Consultation Response from KC Highways Development Management		
2026/90620 Central Warehouse, Bradford Road, Batley, WF17 5LW		
Demolition of existing building and erection of food/drink building with drive thru lane (Class E)		
Date Responded: 25/08/26	Responding Officer: M Zenner	Responding Ref: 13-10SE/9

RECOMMENDATION: HDM considers that whilst additional information has been provided it is not sufficient to overcome highways concerns in relation to the proposals and to comply with NPPF TR6.

PLANNING	
PROJECT	FORMER B&D BOLTS, BATLEY Bradford Road Batley, WF17 5LW
TITLE	Proposed Layout
CLIENT	Darwen Investment Ltd
Drawn	CW
Checked	JHJ
Scale	1:200 @ A1
Date	February 2026
Plan Number	251072 - 203D

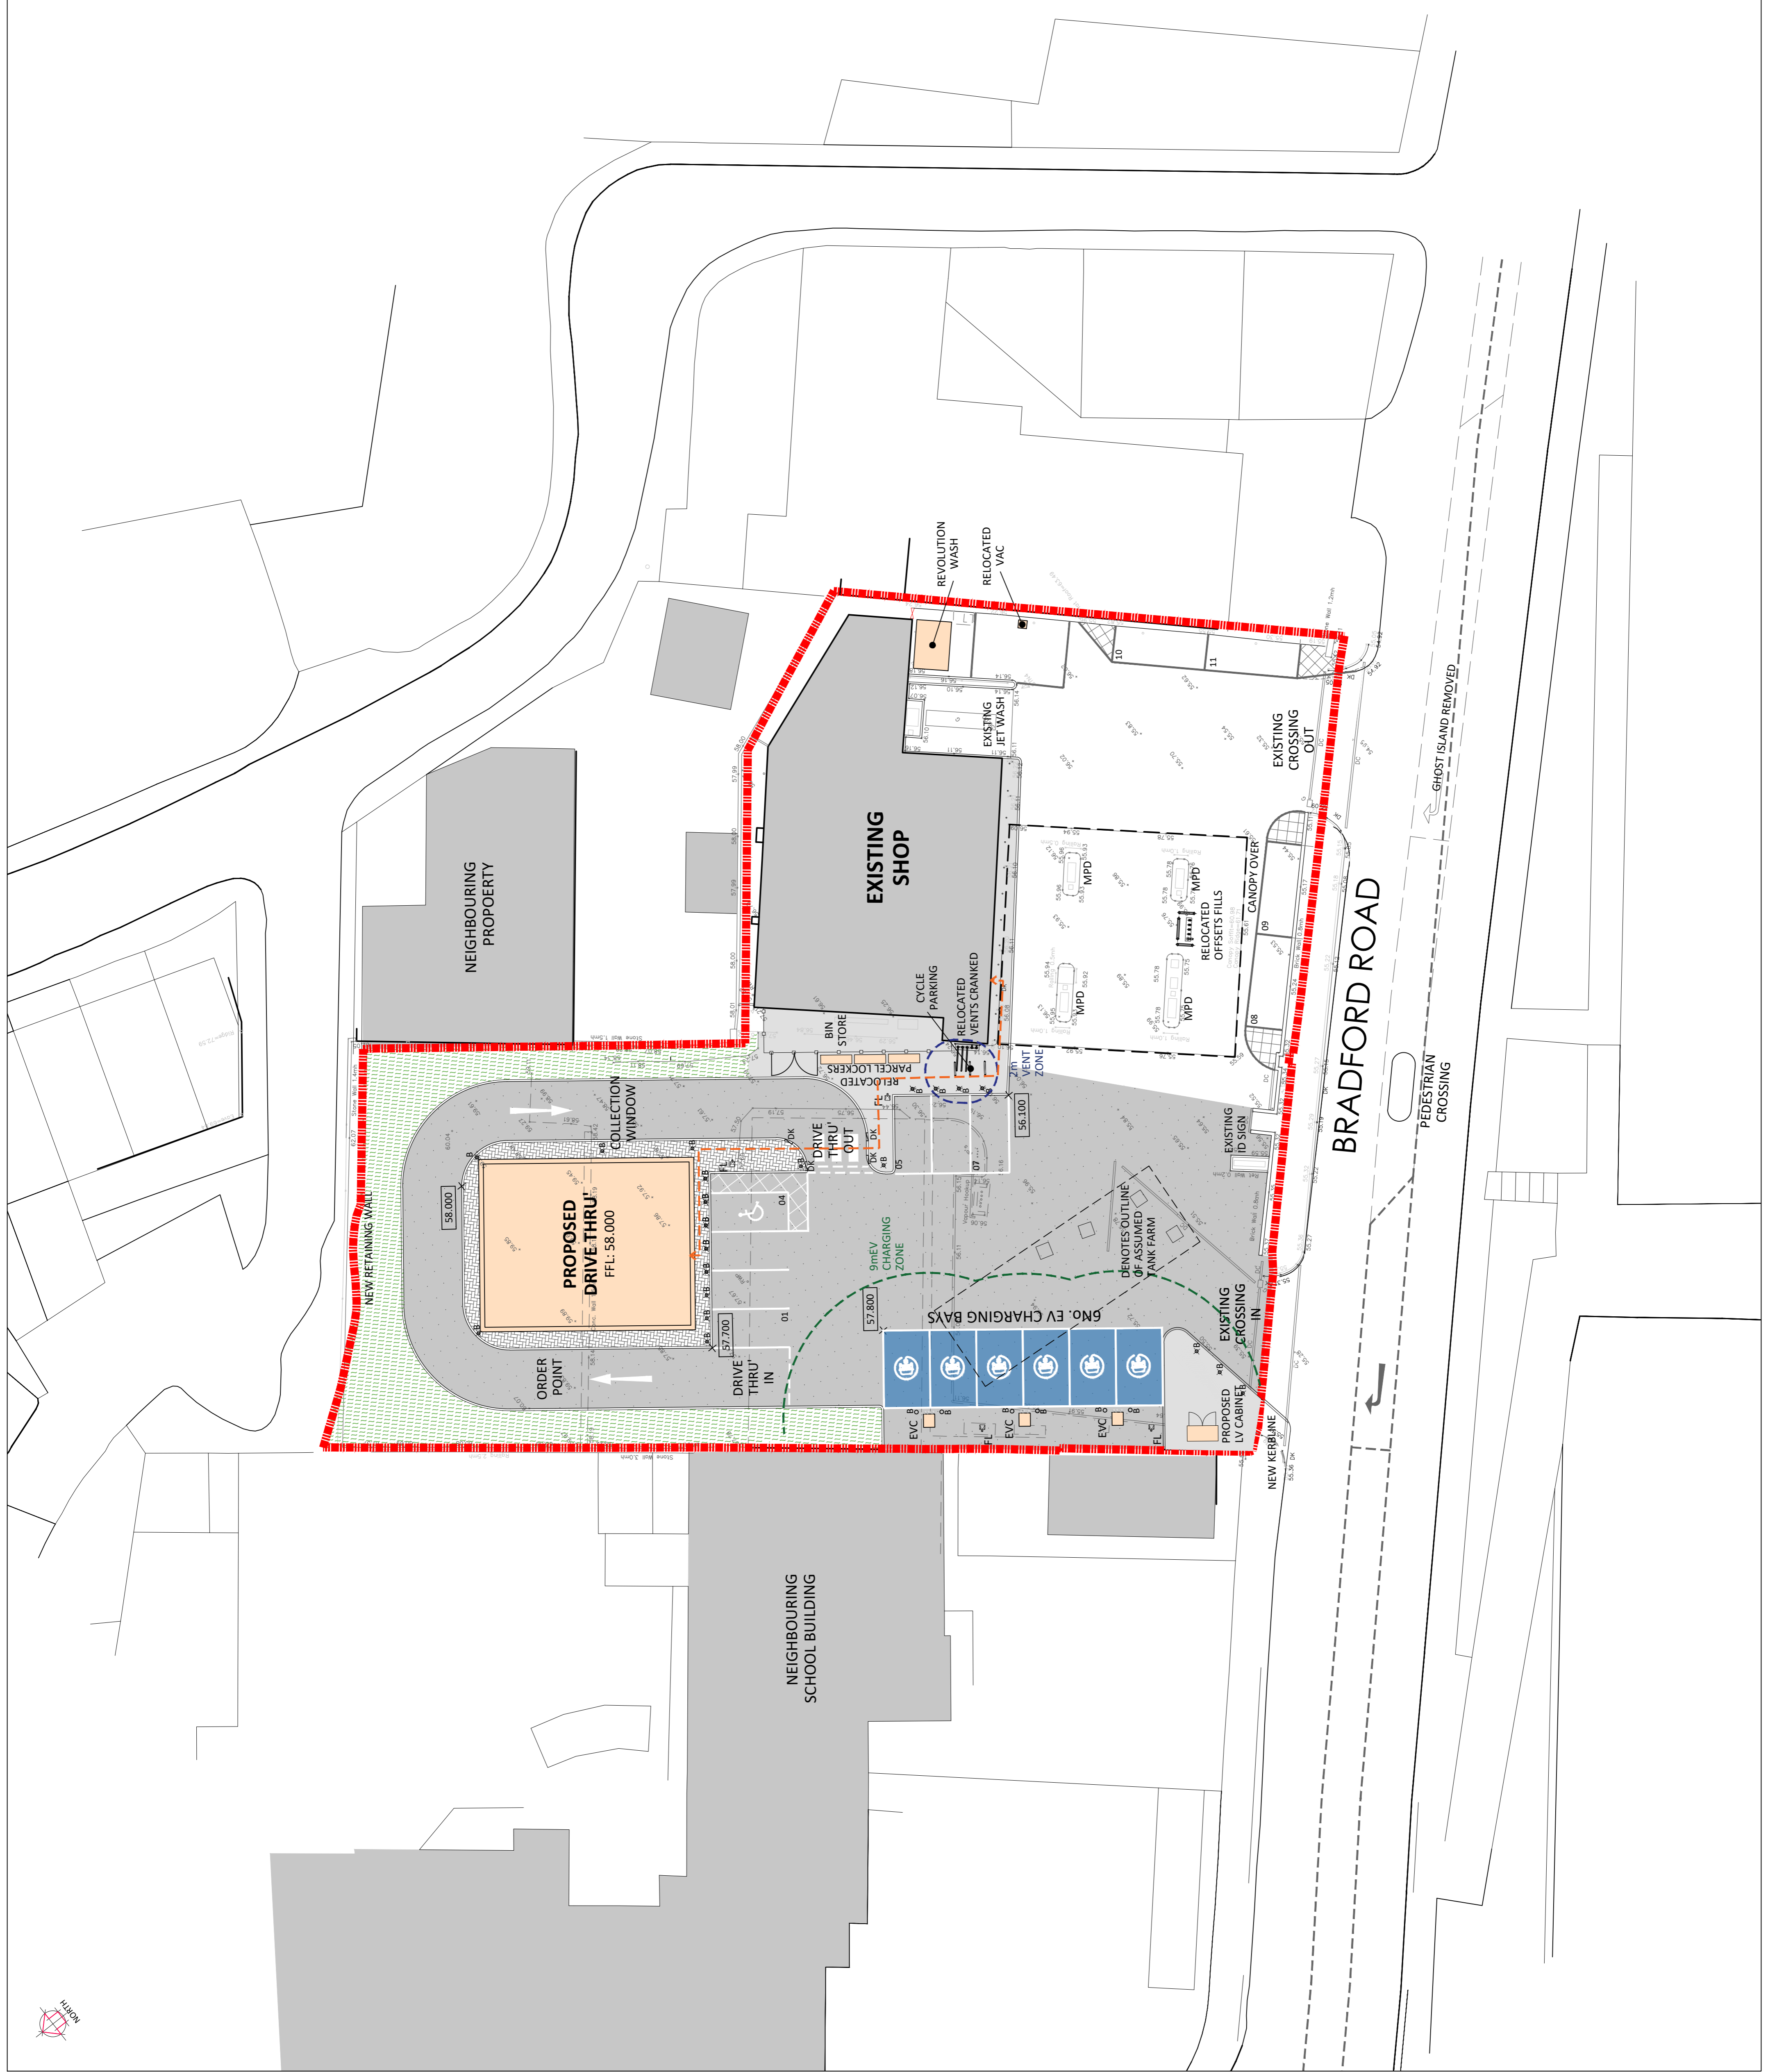
The proposals appear to remove access to the neighbouring property to the rear where there is an existing gate, in the proposed arrangement landscaping is shown in-front of the existing gate but no access is provided from the drive thru loop. The applicant should review and clarify rights of access from the neighbouring property, provide appropriate access if necessary and detail this.

Three Sheffield stands have been relocated within the site adjacent to some bollards and appear to narrow the pedestrian access path to the drive-thru to less than 800mm width which is not accessible; it is also unclear if there is a dropped kerb present. It is also noted that this path runs adjacent to the relocated parcel lockers and therefore the full width of footway provided at that point could be restricted. A zebra crossing marking is located between an area of hardstanding that runs alongside parking space no 5, this hardstanding is less than 1.6m depth. While it appears that dropped kerbs are proposed at either side of the zebra crossing marking, the kerbline is exceptionally curved to the north which does not appear to provide priority for pedestrians. Whilst the footway that extends further to the north is in excess of 2m width it narrows to less than 0.7m between the bollards and the entrance door to the proposed drive thru / A3 unit which is not acceptable.

A pedestrian path is now shown running along the eastern edge of the EV bays and a zebra crossing marking which links across to a pedestrian path that runs behind parking spaces 1-4 which is approximately 1.2m wide. Whilst this is an improvement on the previous design, it is not clear if the route is accessible due to the presence of bollards and kerbed islands and the issue raised above in regards to the narrow footway width at the entrance door would be an issue for this route too.

The proposed building is located centrally within the space to the rear of the site with a vehicle loop around it and proposes car parking directly in-front of the unit, adjacent to the 'out' point of the drive thru and adjacent to the 'in' point of the drive thru. No details are shown of the order point/s.

HDM is also concerned that there is limited visibility for those exiting the drive thru lane due to the presence of car parking spaces 5-7.

The provision of parking bays 8 and 9 along the Bradford Road frontage removes the ability for vehicles to exit the site unless two fill pumps in a row have no vehicles parked at them.

The submitted TS states that there are 25 operational parking spaces proposed as part of the development which broadly aligns with the local standard requirements. HDM would contest this, as 6 of the spaces are for EV charging and 8 of the spaces are located at fuel pumps and therefore would be unlikely to be available for users visiting to use the drive-thru unit or for non fuel retail purchases. 11 general purpose car parking spaces are proposed according to the submitted site layout plan.
